**Re: Planning Act 2008 – Application by London Luton Airport Ltd for an Order Granting Development Consent for the London Luton Airport Expansion Project PINS Ref. No. TR020001**

I am writing to you concerning the absence of any response from the Applicant to the representations raised by my clients, Holiday Extras Ltd, at the Deadline 9 stage [**Document REP9-079**], which in turn referred to my client's Deadline 7 submissions at **Document REP7-102**.

Figure 8.9: Car Parking Proposals - Assessment Phase 2a

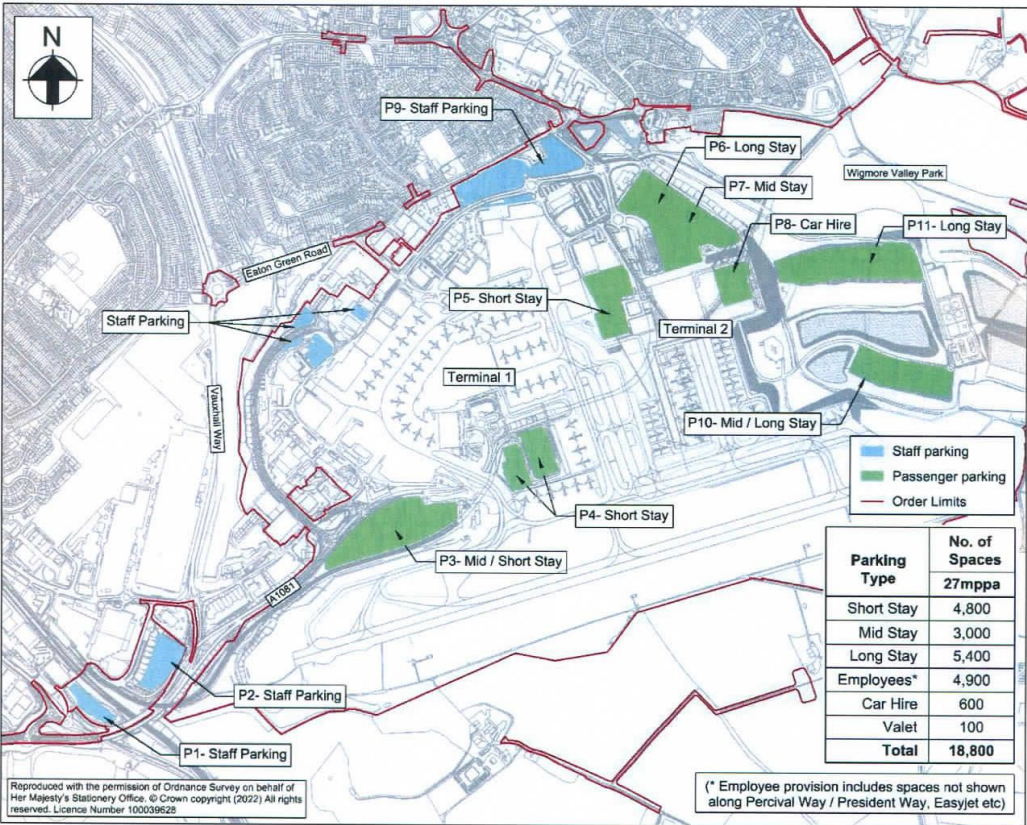
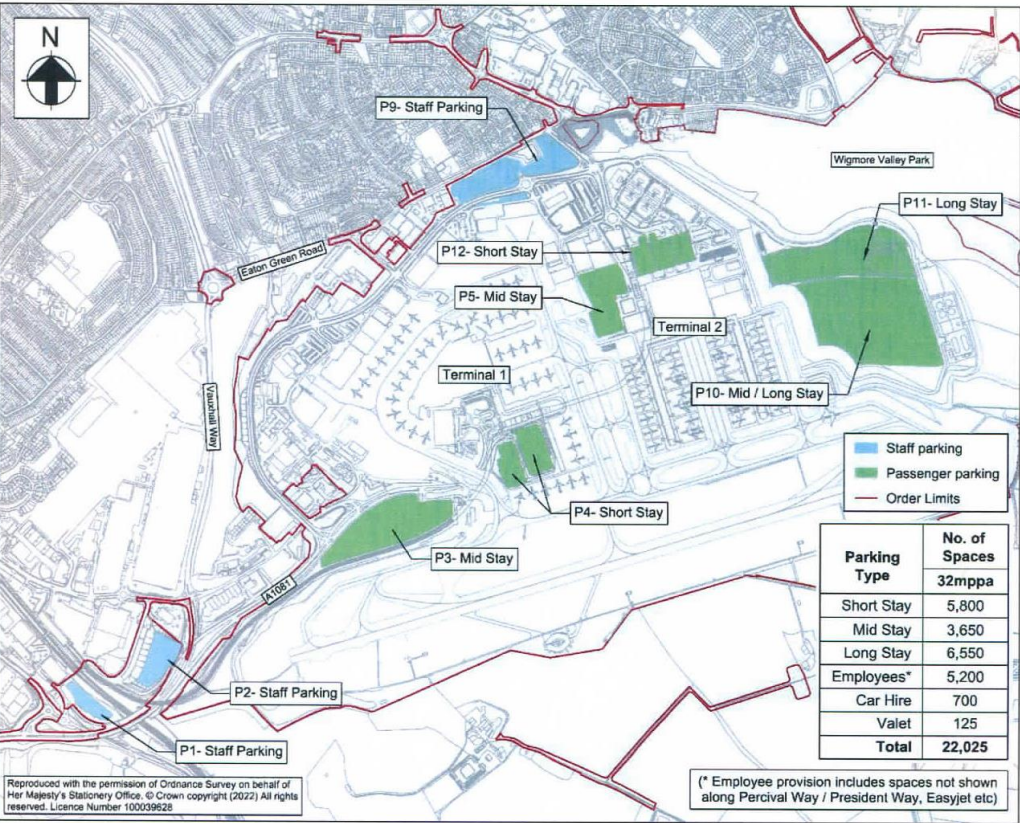
The final sentence of paragraph 3.3.4 of this updated planning statement says “*The development of long stay and employee car parking (where the minimum stay is expected to be in excess of six hours) in this zone is permitted.*” The same two car parks are shown in Figures 8.9 and 8.10 of **Document AS-123** at Phases 2a and 2b of the DCO development as being used for staff parking. I can find no reference in the DCO application document library to the use of the same two car parks for passenger car parking, at a time when previously references have been made to staff car parking.
